AB/22/22/PL

61 Maltravers Street Arundel BN18 9BQ

Variation of condition 2 imposed under AB/109/18/HH relating to approved plans.

NOTES:

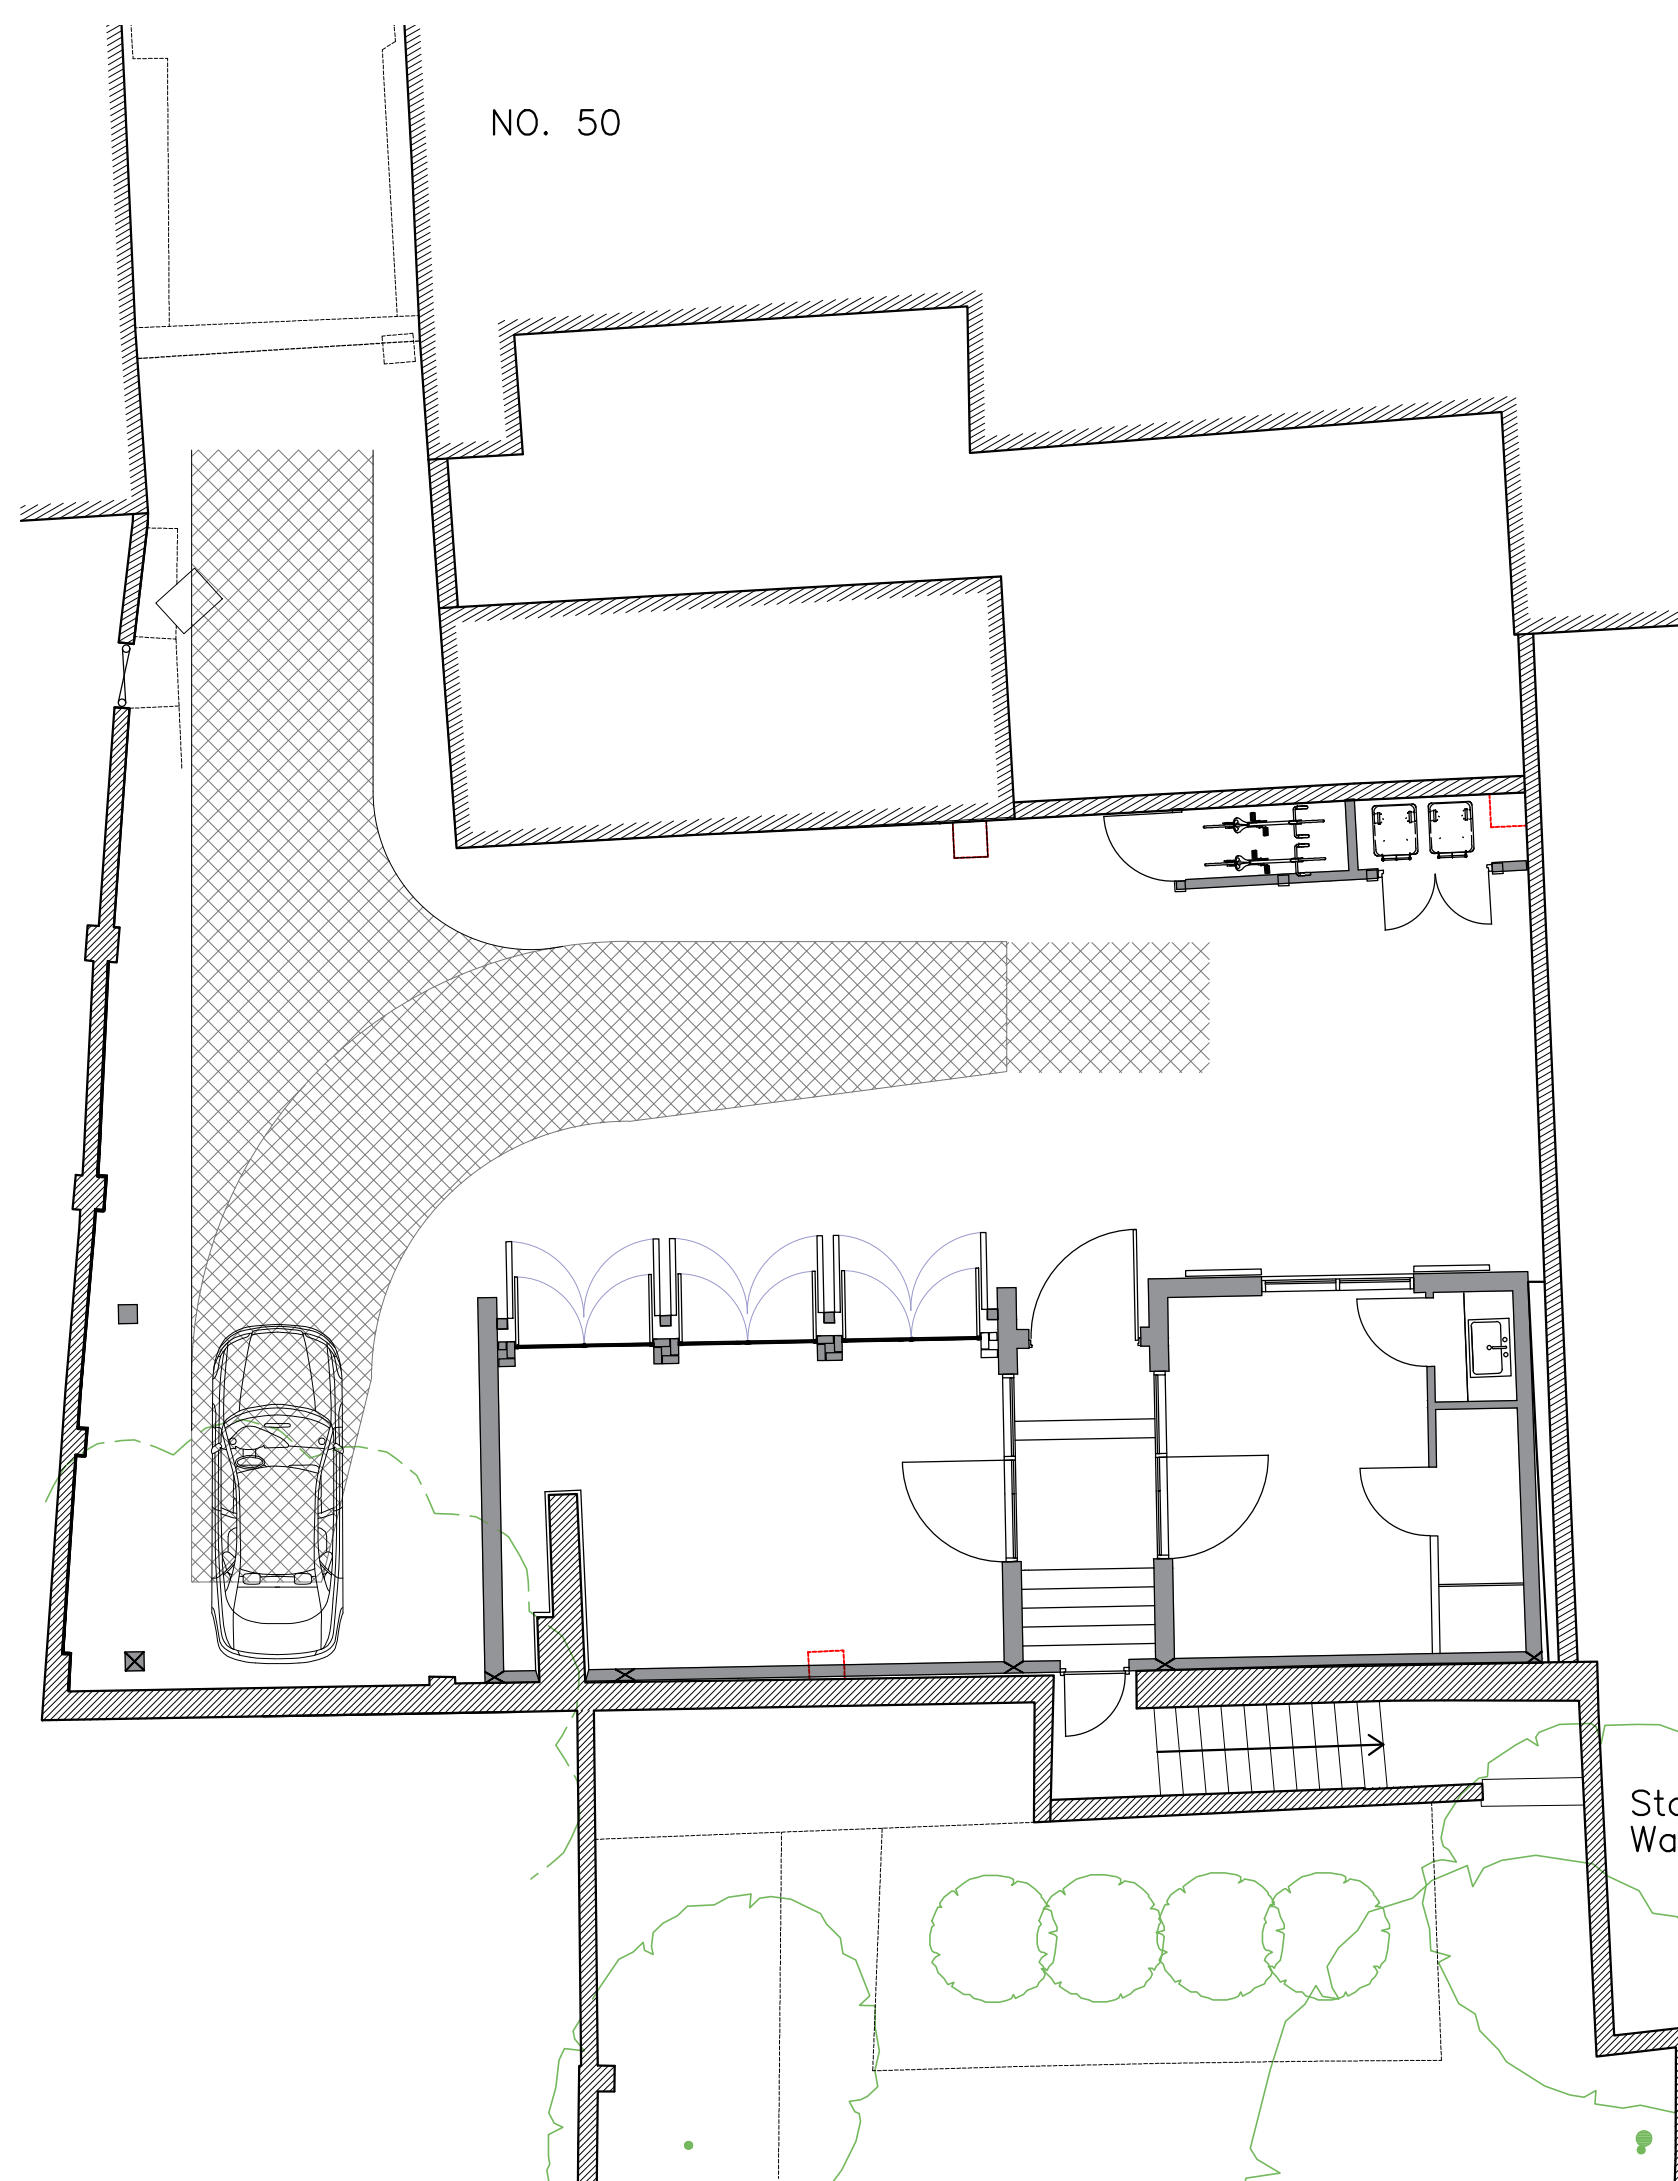
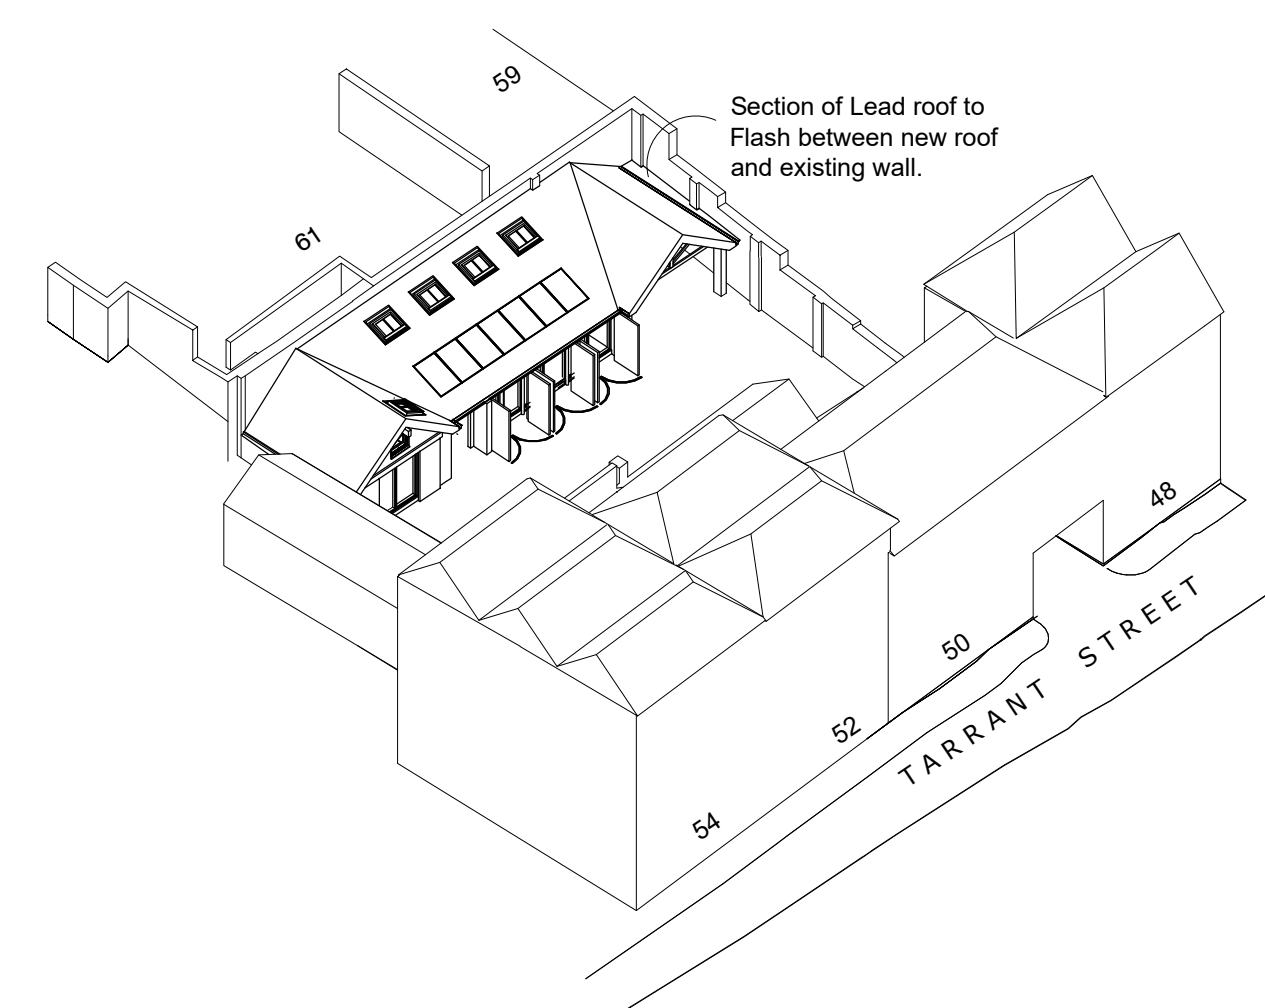
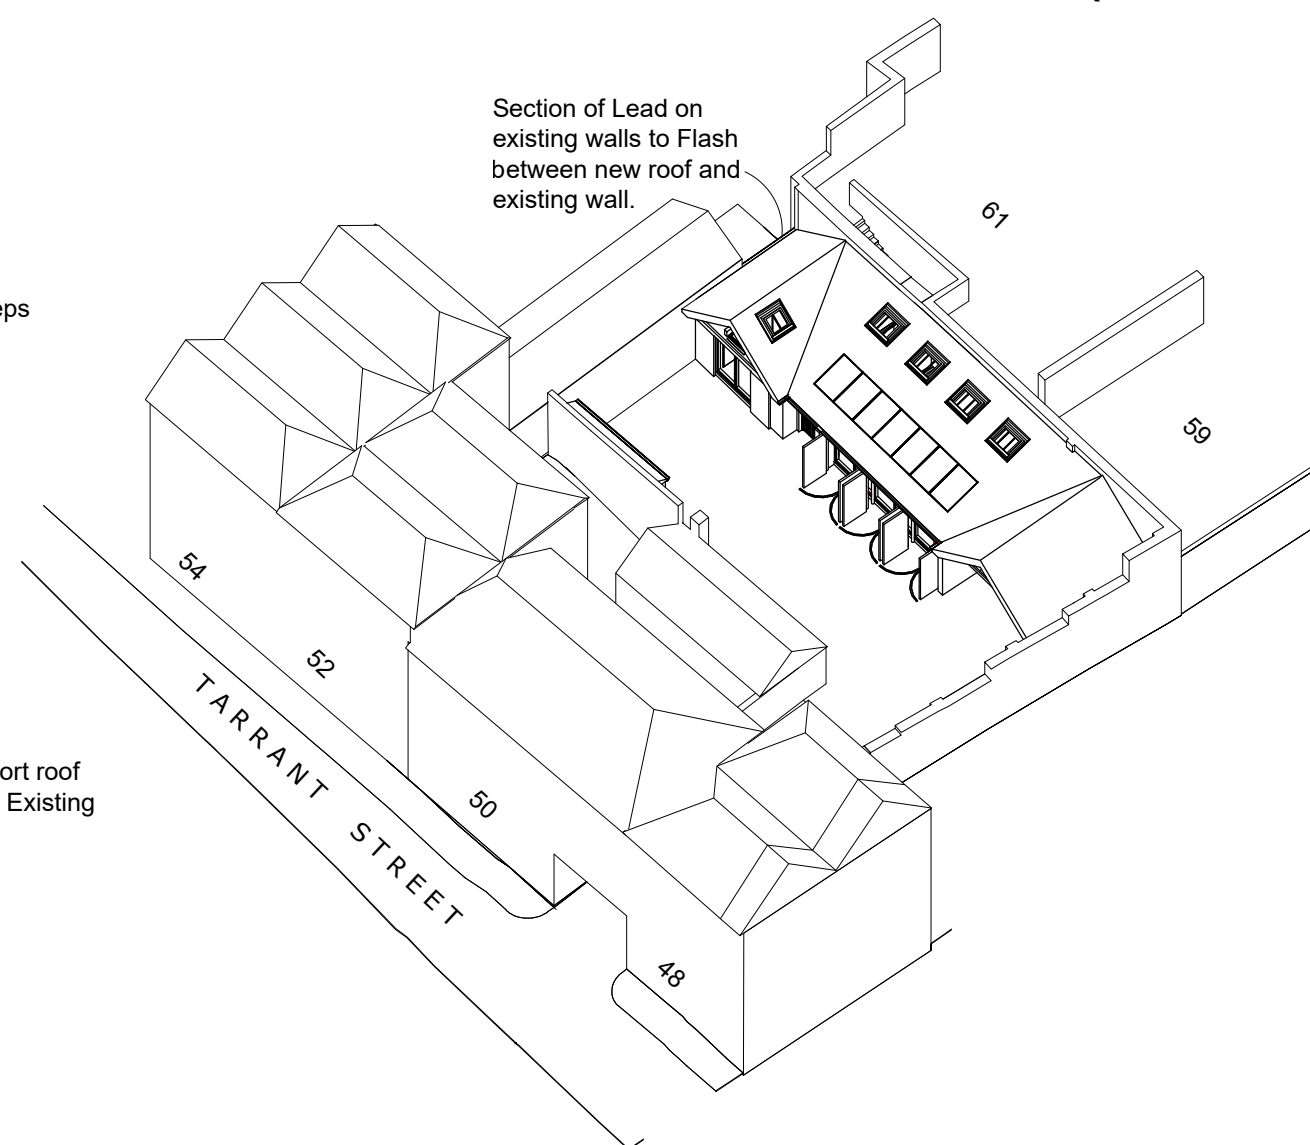
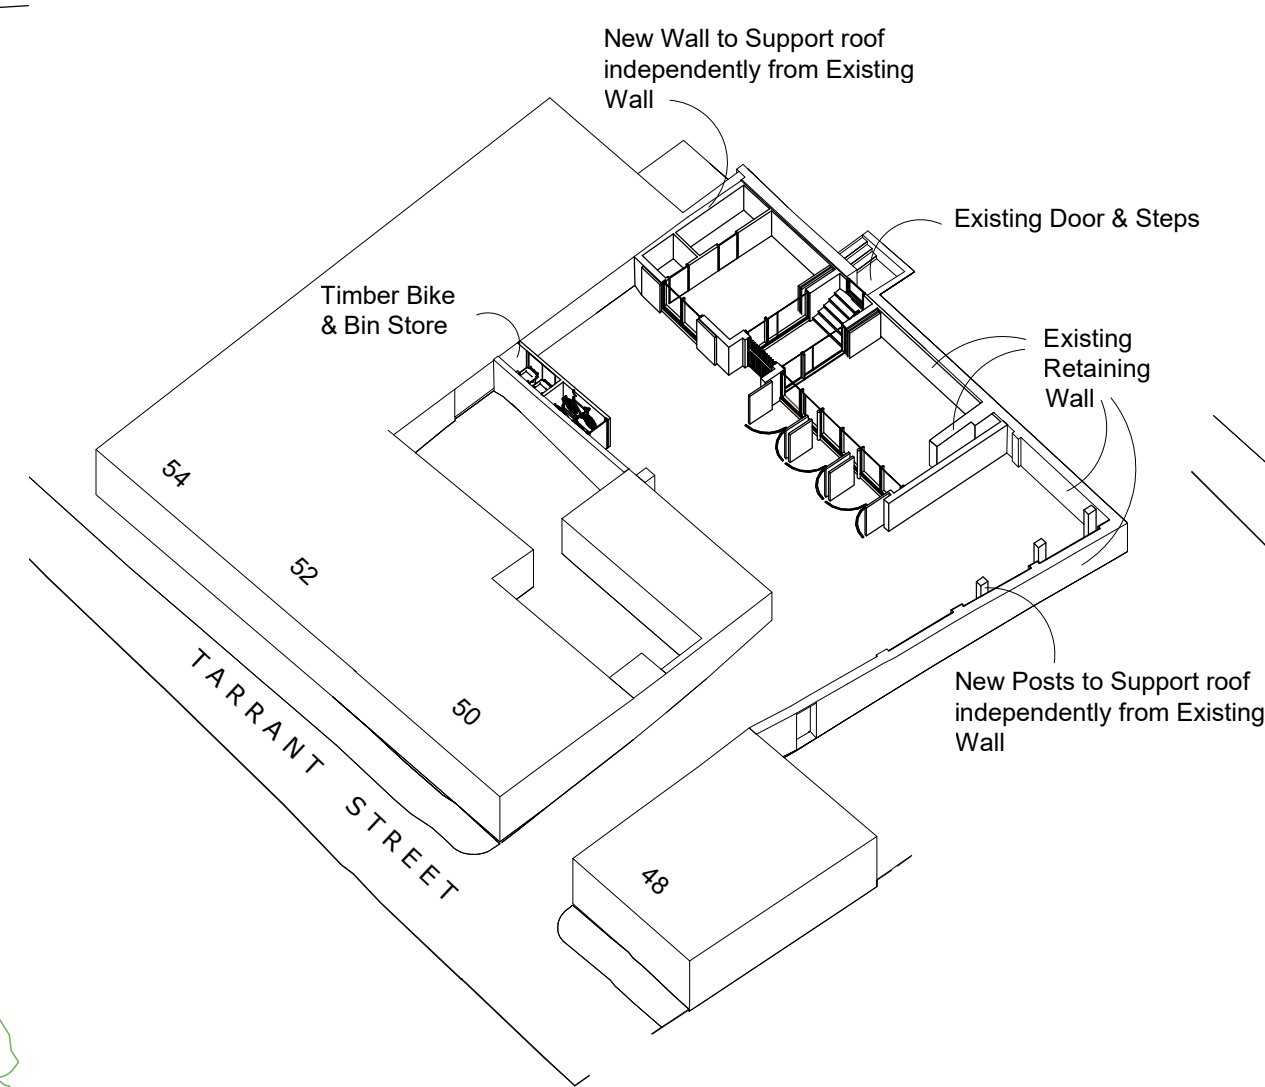
The proposal is to vary the plans approved under application AB/109/18/HH. Based on the plans provided as part of this application it is not fully clear how the plans differ, and as a result I have had to compare them with the previously approved ones. It would have helped if a statement had been provided identifying the relevant changes. It would appear that there are a number of changes to the roof structure which would affect its appearance. However, these changes are not considered to cause harm and would be located so as to not be visible from Tarrant Street.

As before, the proposed design appears to draw upon a concept of a garage/stabling block through the use of simple façade treatment and the incorporation of a series of closing garage style doors. This concept reflects the existing character of the site, along with the previous use. The success of such an element of the design will depend upon the detailing of the window/doors. It is suggested that the glazing should be set back so as to create a shadow line, which reduces the impact of the glazing. Full details of the materials, proposed joinery and windows/doors and their treatment should be provided if you are minded to approve the application. These details can be provided by way of condition.
